**RE: Response to Comments
Level I Minor Residential Application
7 Diamond Pass
Peaks Island
Portland, Maine**

We have reviewed your comments specific to the Site Plan Requirements provided on August 28, 2017 for the Level I Minor Residential Application. Please find our responses to the comments below in *italics*.

enc. Revised Site Plan Set, Rev. 1, September 5, 2017

12 CONCRETE WALL  
SCALE: 1/2" = 1'-0"

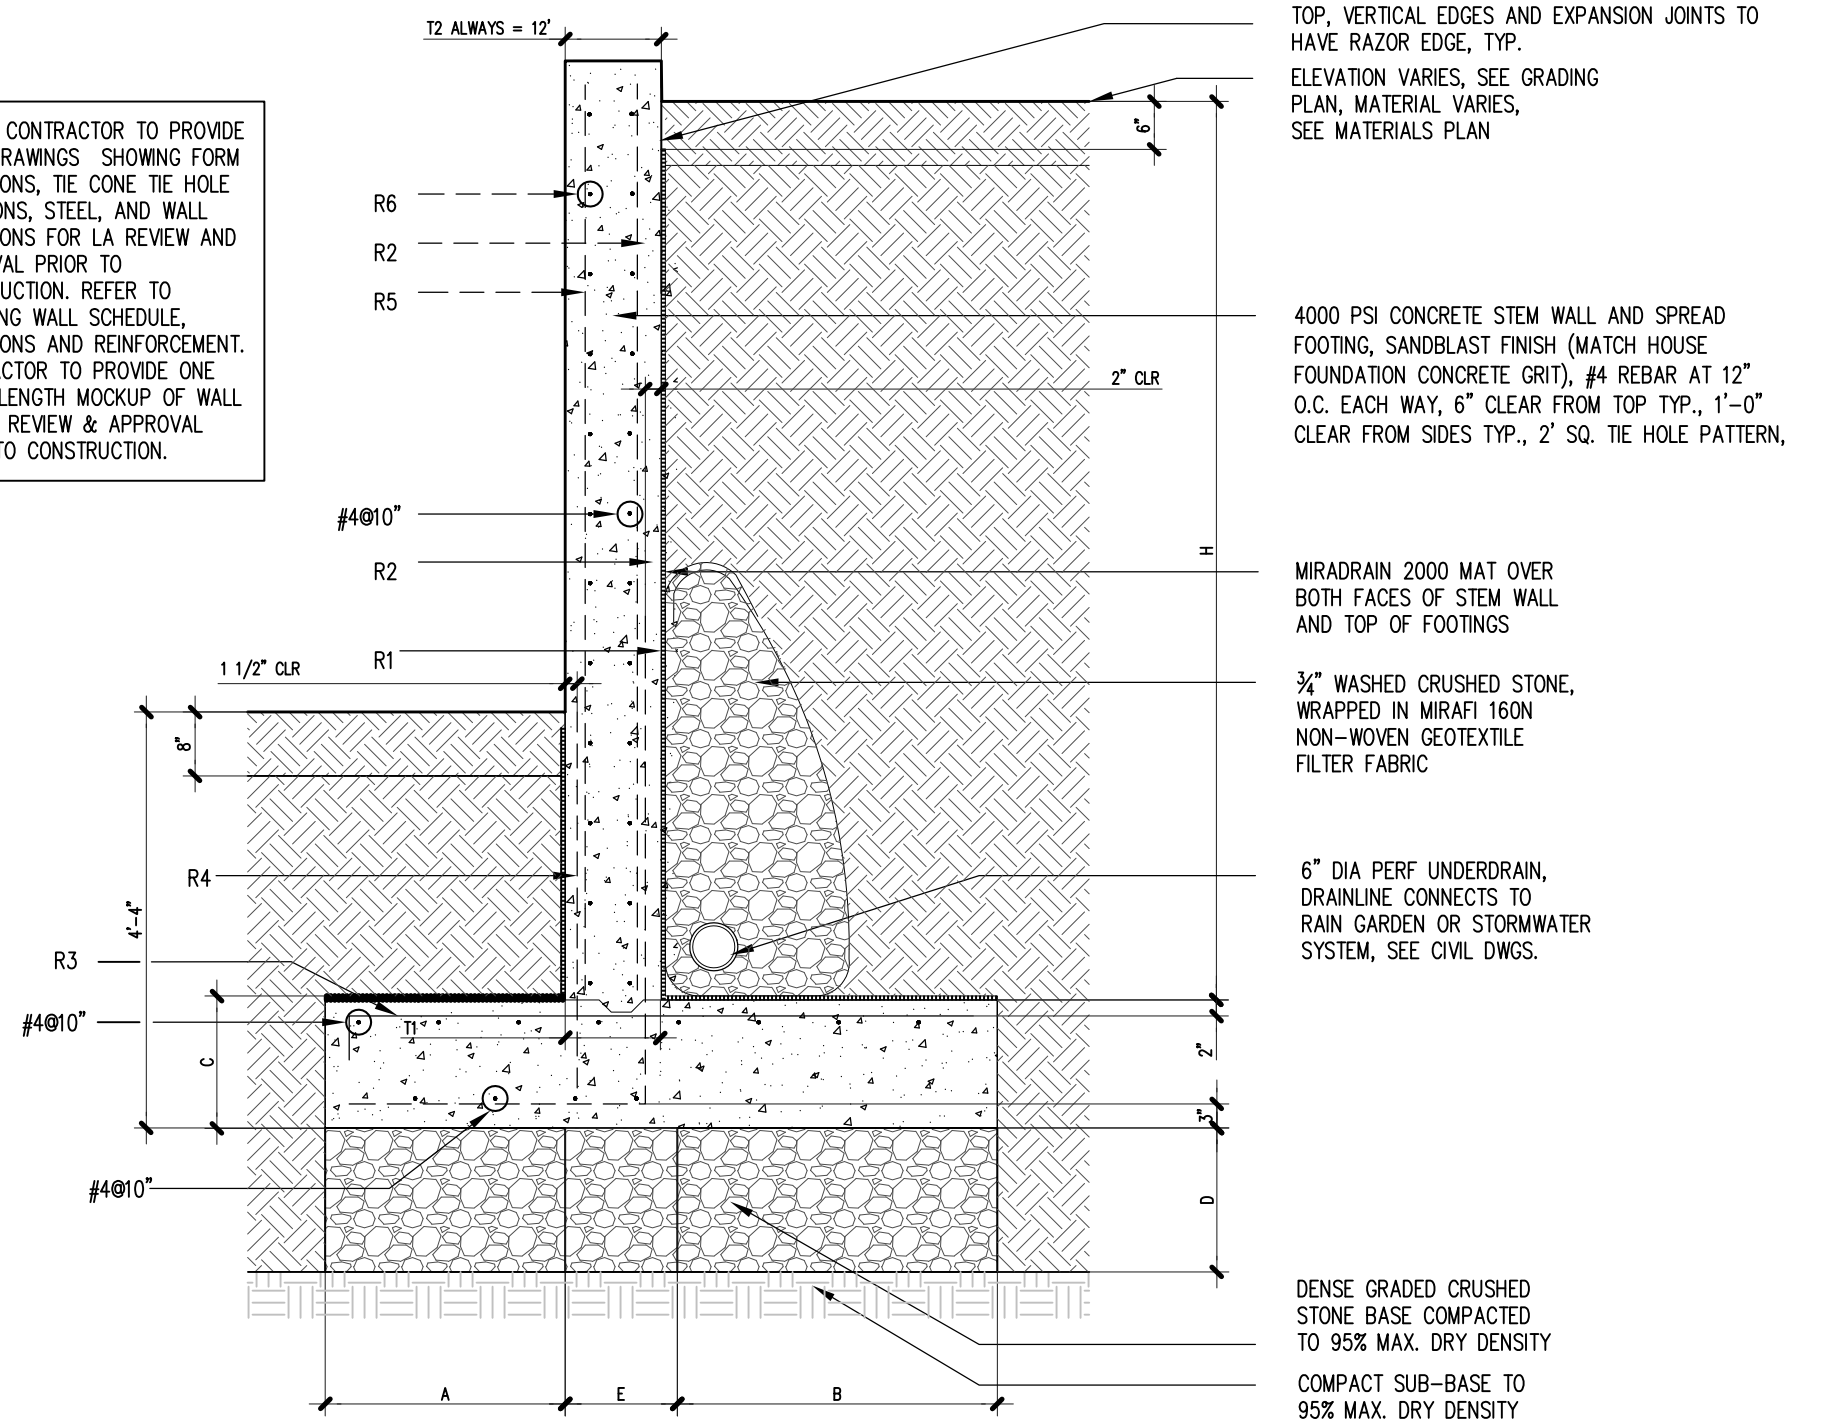
- d. Design details for all retaining walls having a total height of 4' or more. (If specific details already exist, including elevations for top and bottom of wall, please include a note indicating which plan sheet includes these.)

As discussed, top of wall elevations and finish grade elevations on both sides of the retaining walls are provided on Sheet C3.0. Detail 12 on sheet L5.0 provides a structural detail for the retaining walls. A detail reference has been added to the site plans.

3 FOUNDATION DRAIN DETAIL

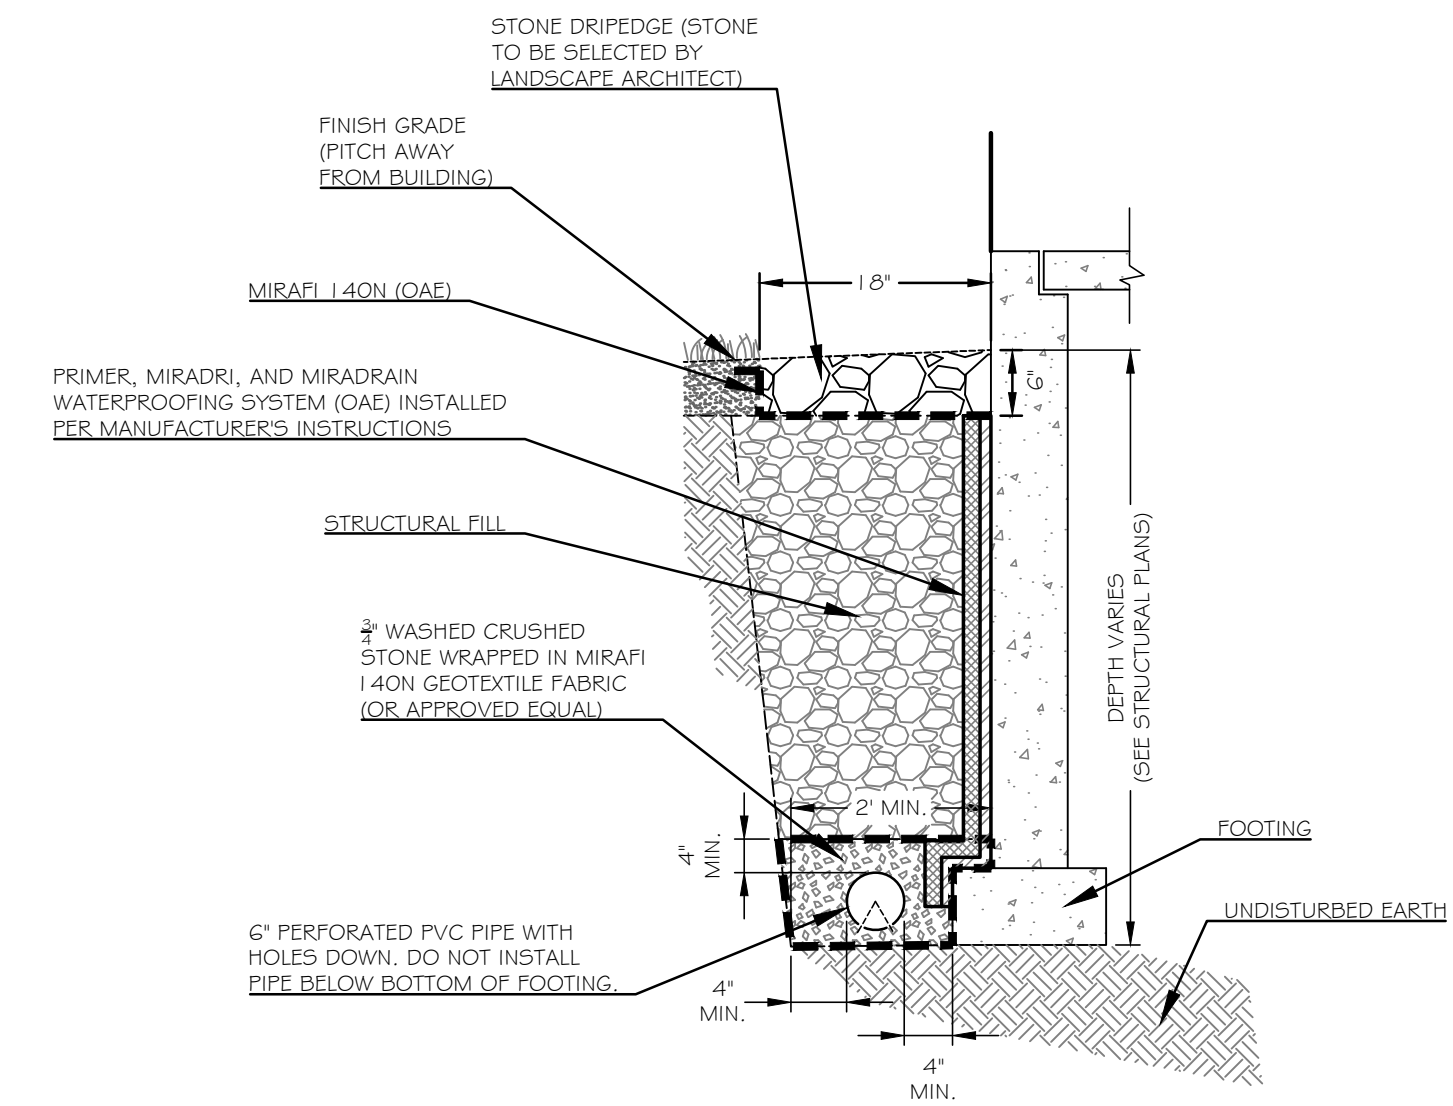
- c. The grading plan should make clear that neighboring properties will not be negatively impacted by stormwater surface drainage, ie. Adding drip edge around

the foundation, berming and swaling so that stormwater is directed to the front or rear of the site.

Per our conversation, we have added a leader note on Sheet C3.0 indicating that the contractor shall grade the site along the southern property line to prevent stormwater from flowing offsite. The lawn area on the west side of the house has also been regraded to direct runoff primarily towards the ocean instead of onto the Diamond Pass ROW. A stone dripedge has been incorporated into detail 3 on sheet C4.1.
